Application by Ecotricity (Heck Fen Solar) Limited  
Heckington Fen Solar Park

## **The Examining Authority's written questions and requests for information (ExQ1) Issued on 17 October 2023**

**Supplementary Plan: Individual sheets showing isolated work areas**  
**Sheet 12 of the Works Plans**

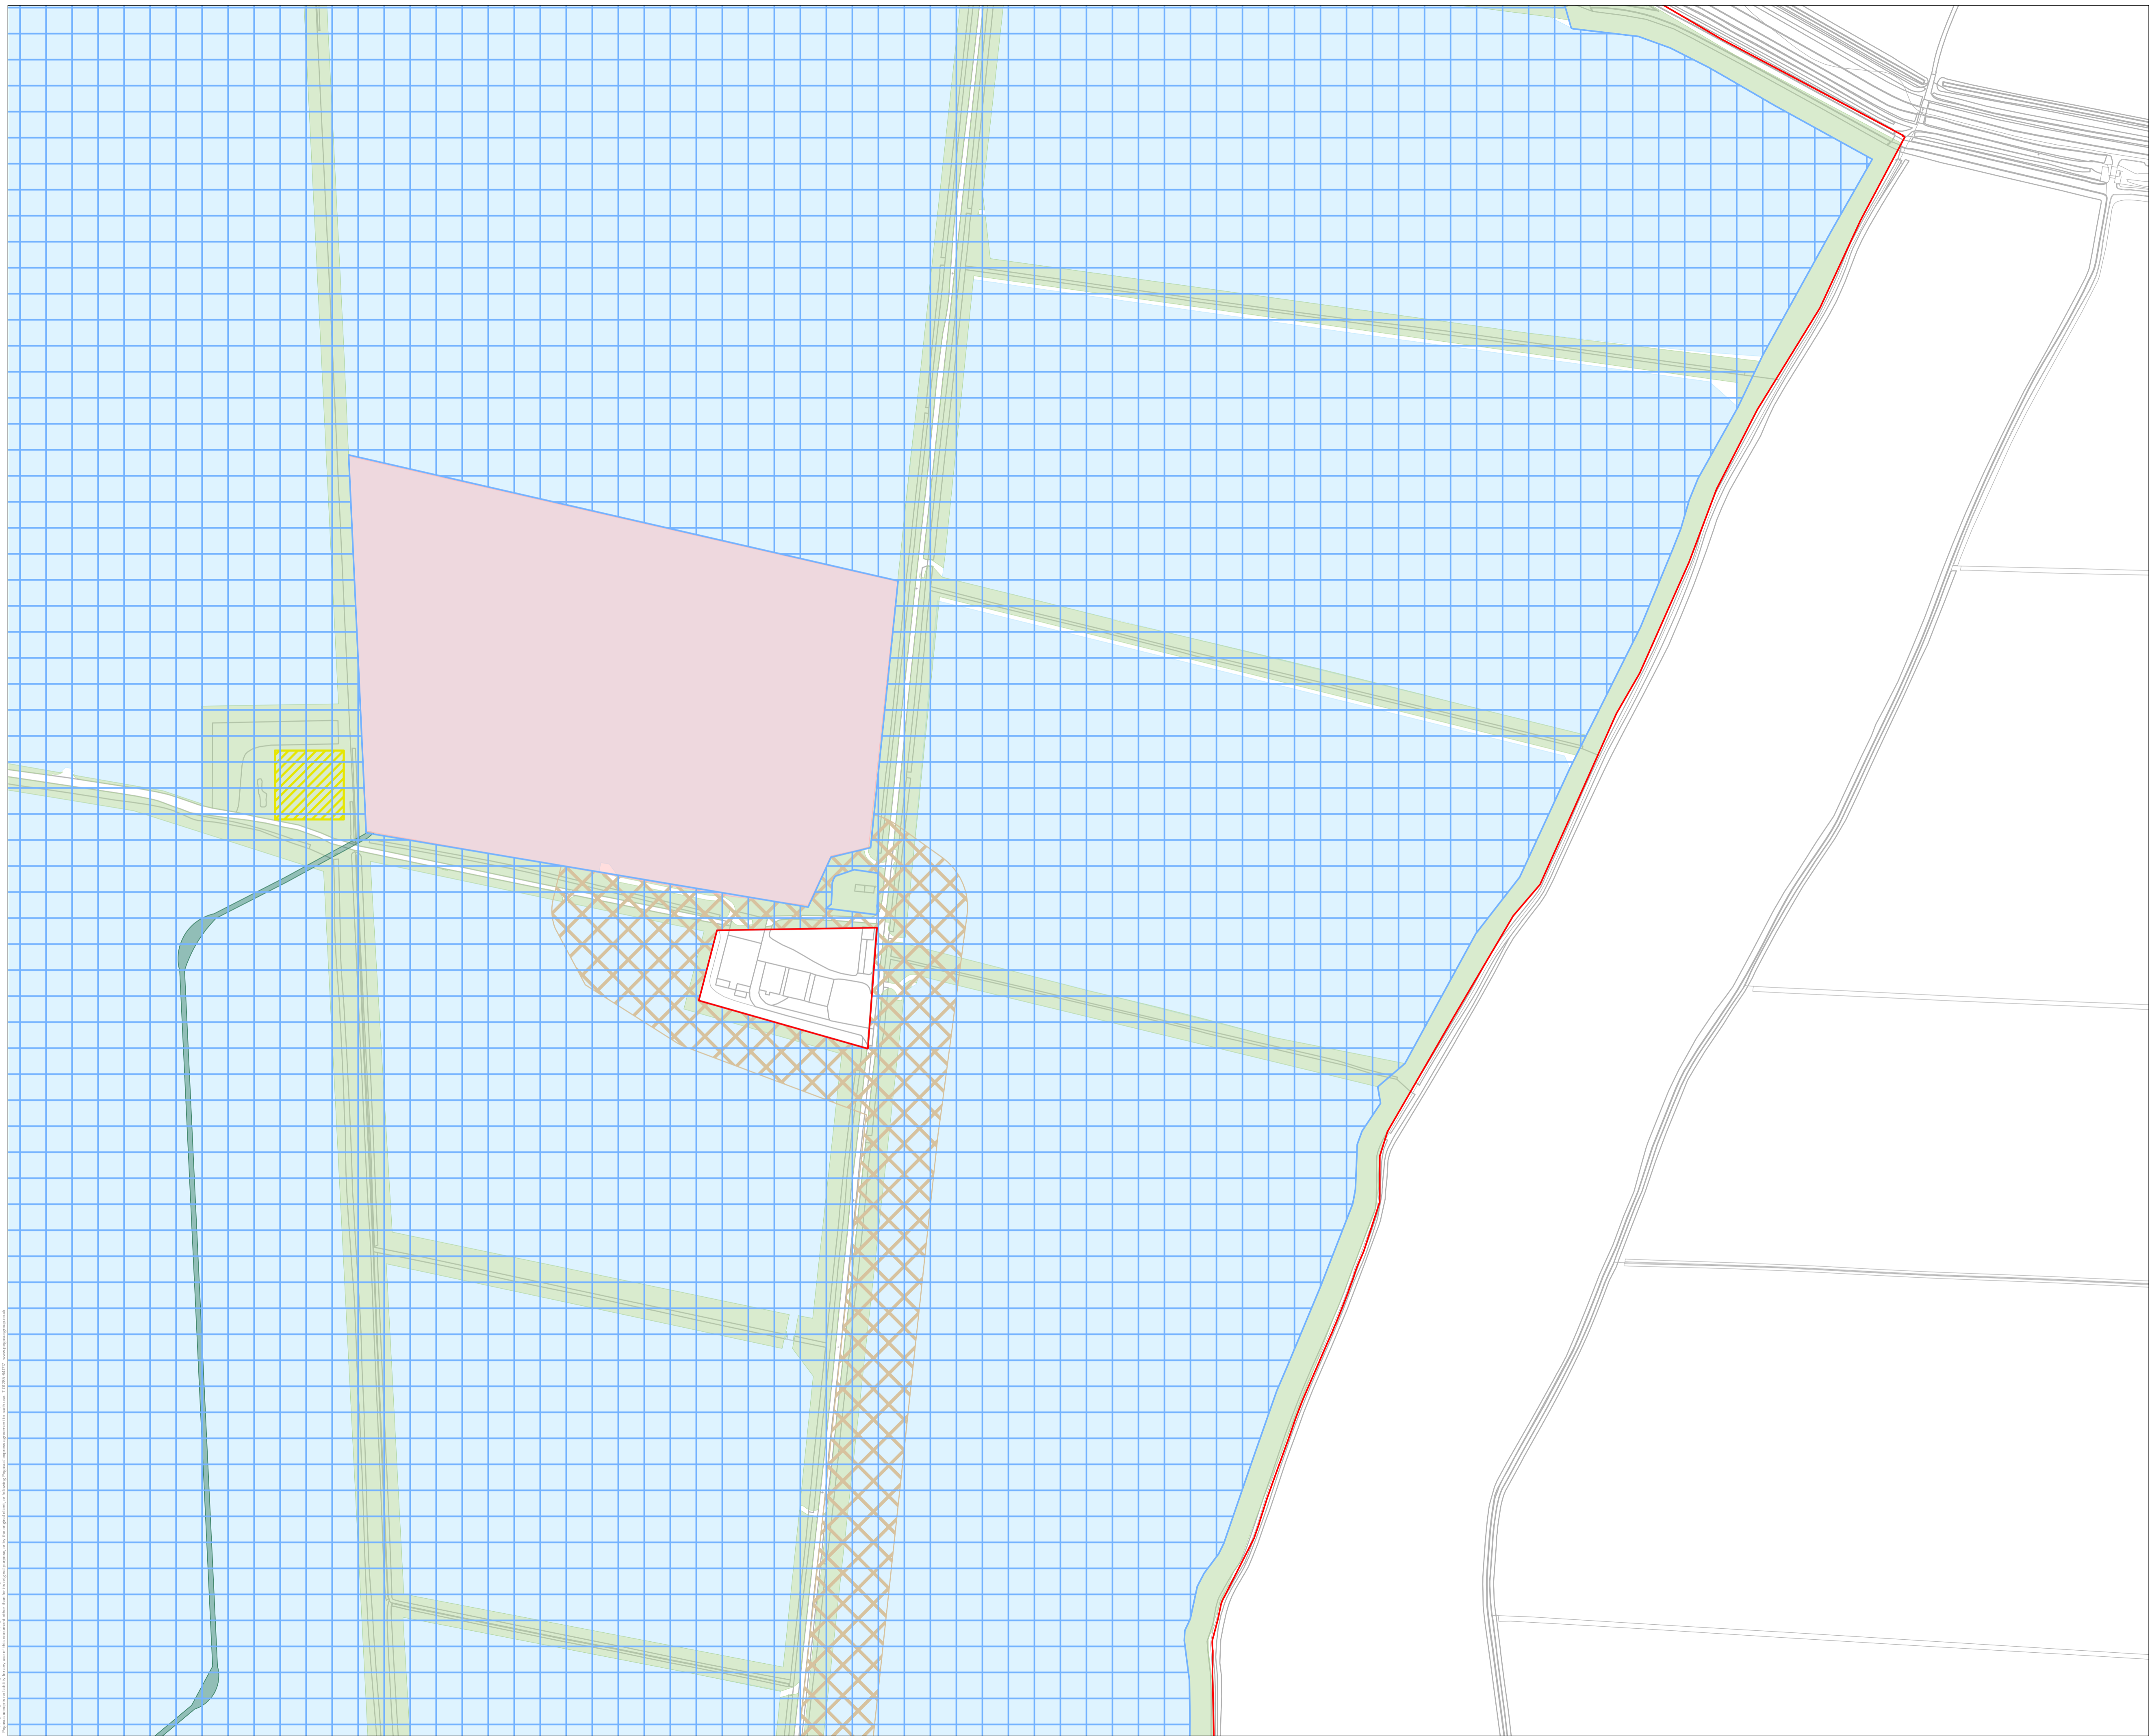
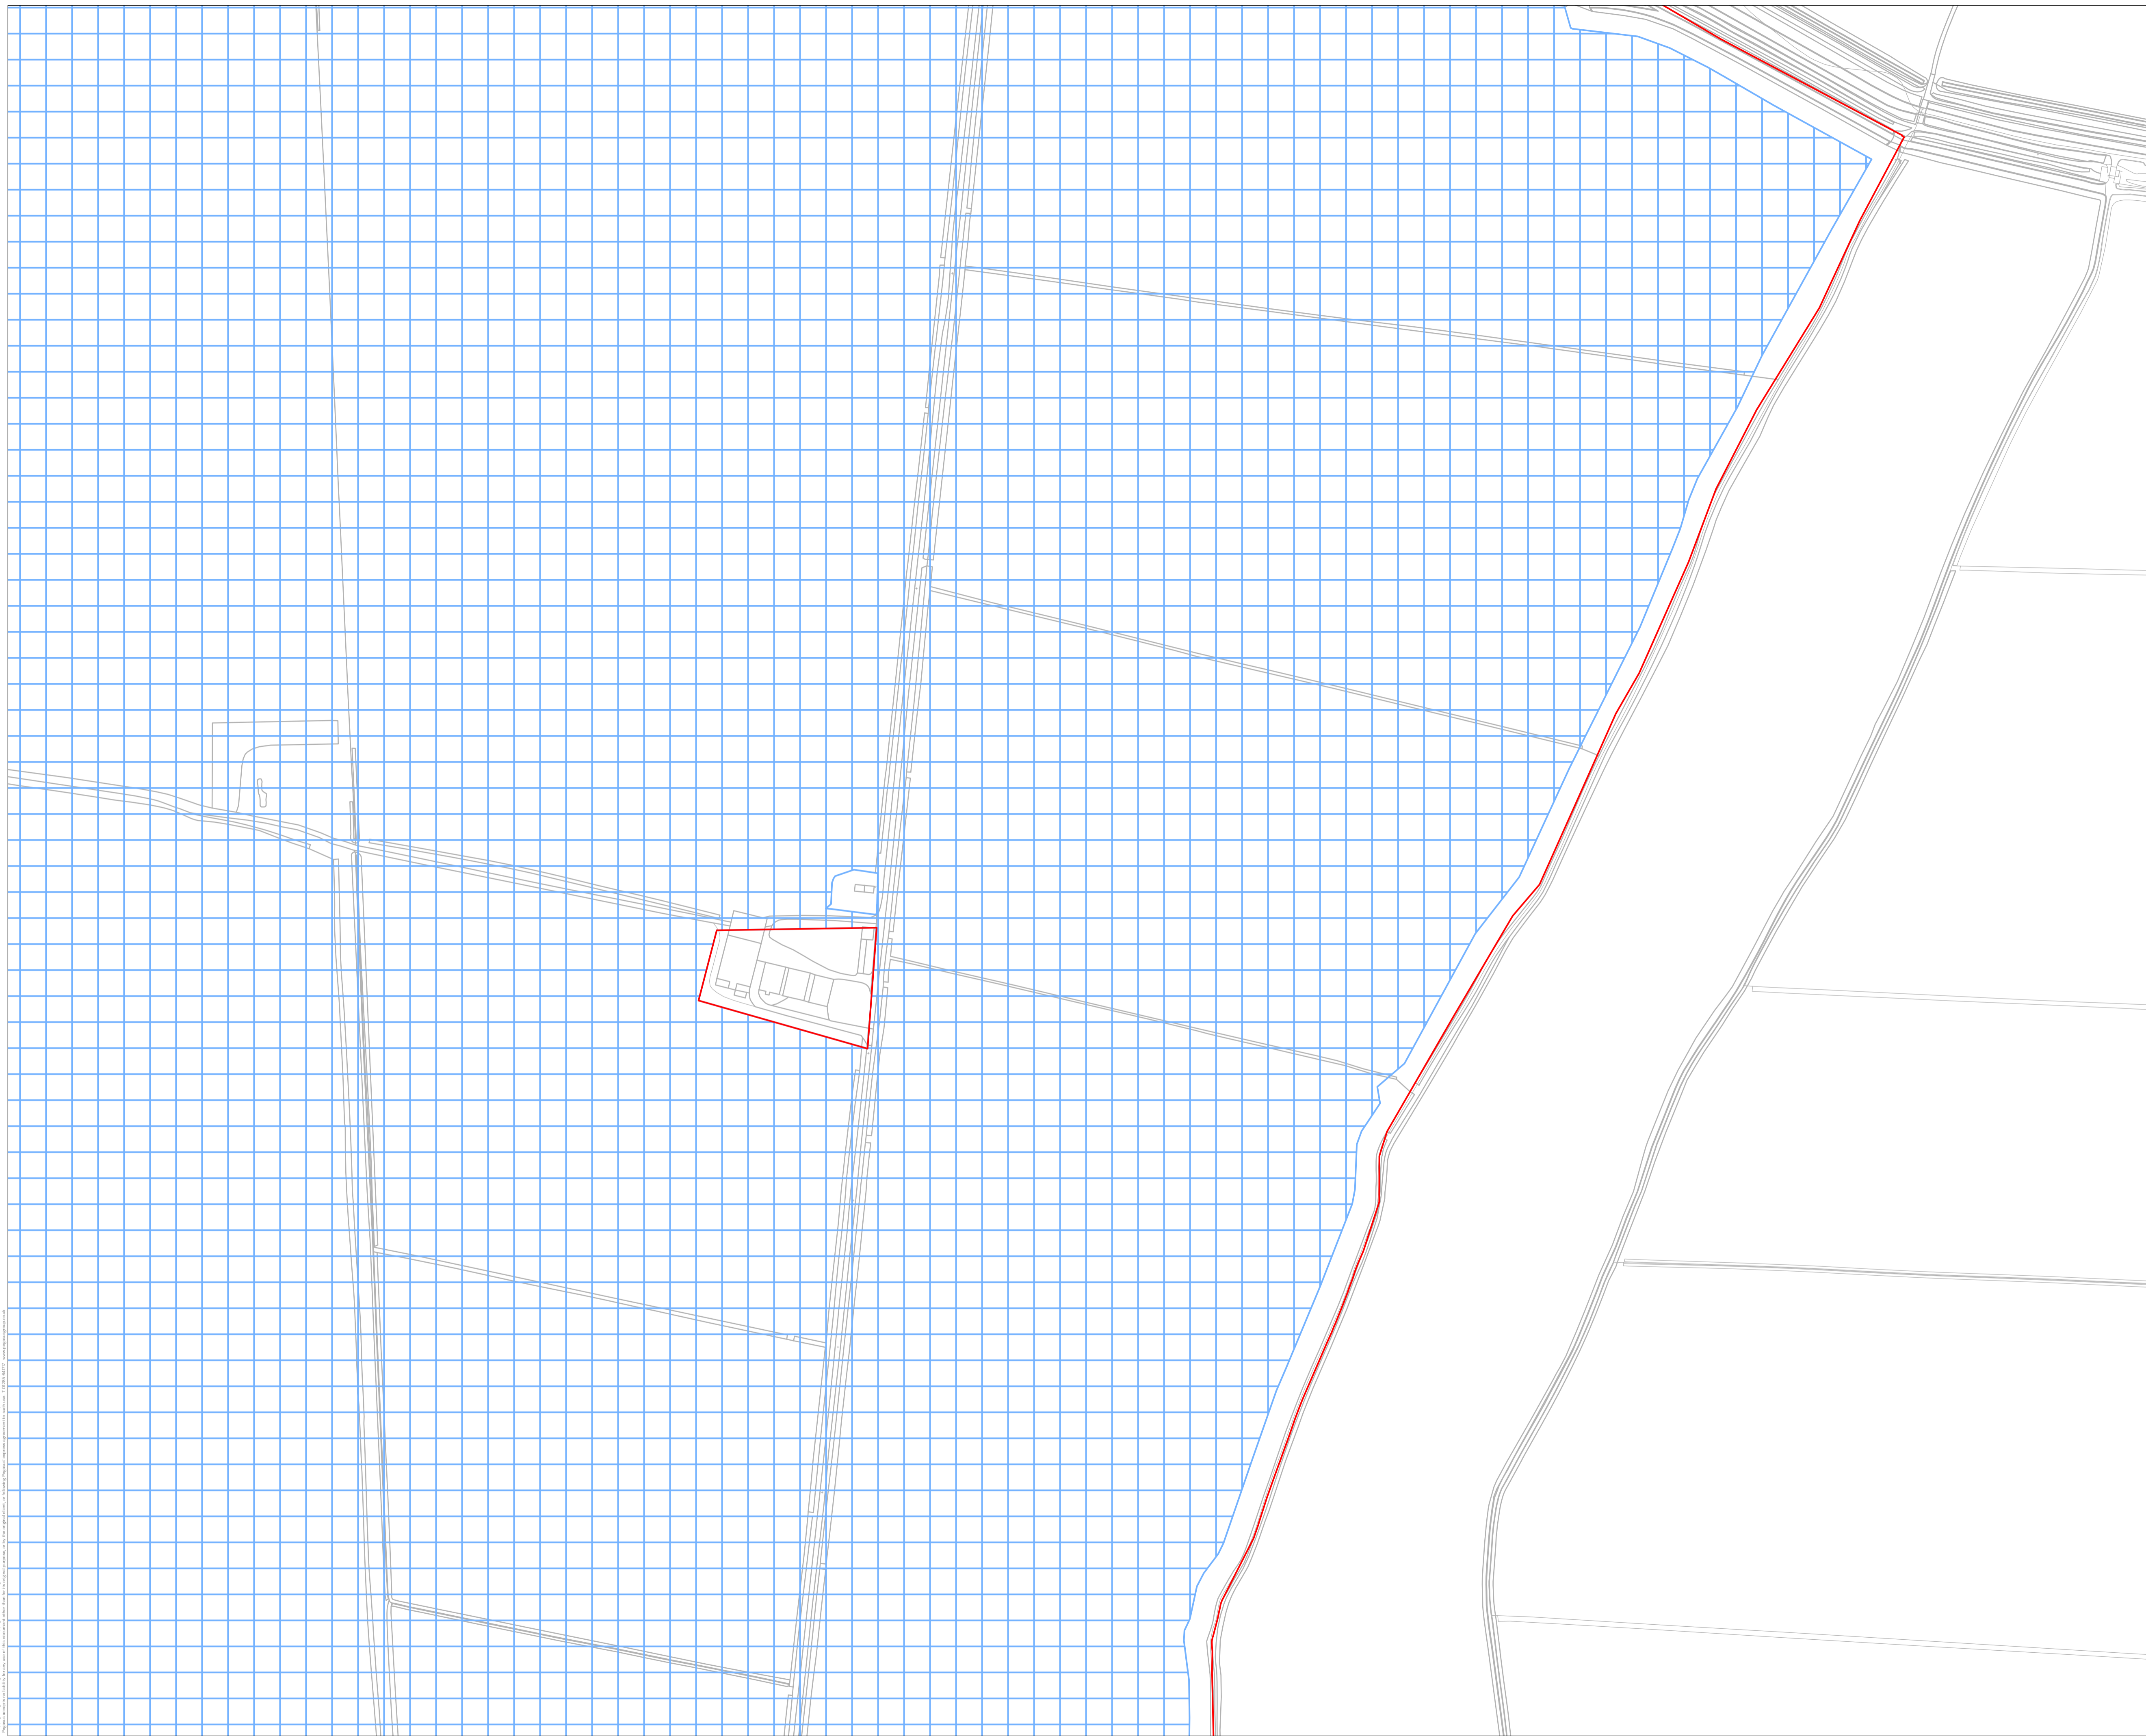
<b>ExQ1</b>	<b>Question to:</b>	<b>Question:</b>
<b>1. GENERAL, MISCELLANEOUS AND CROSS-TOPIC QUESTIONS</b>		
GEN.1.1	Applicant	<p>Sheets 5, 6, 12 and 13 of the Works Plans [PS-014] show numerous overlapping Works No's around the on-site substation and the Bicker Fen substation. Due to the scale of the plans and the overlapping colours/patterns the exact boundaries of many of the Work No's in these areas of the Proposed Development are ambiguous.</p> <p>Provide individual plans to clearly show the extent of each of the Work No's in these areas. These should not supersede the Works Plans but would be supplementary to them.</p>
GEN.1.2	Applicant	<p>Paragraph 3.4.1 of Environmental Statement (ES) Chapter 3 [PS-053] states that the layout of the Proposed Development has evolved taking into account "<i>planning and environmental policy objectives</i>".</p> <p>Could the Applicant provide further detail for each of the relevant "<i>environmental policy objectives</i>" and design objectives set out within the Statement of Need and Planning Statement [PS-142], and how these have been taken into account within the iterative design process described within the ES.</p>
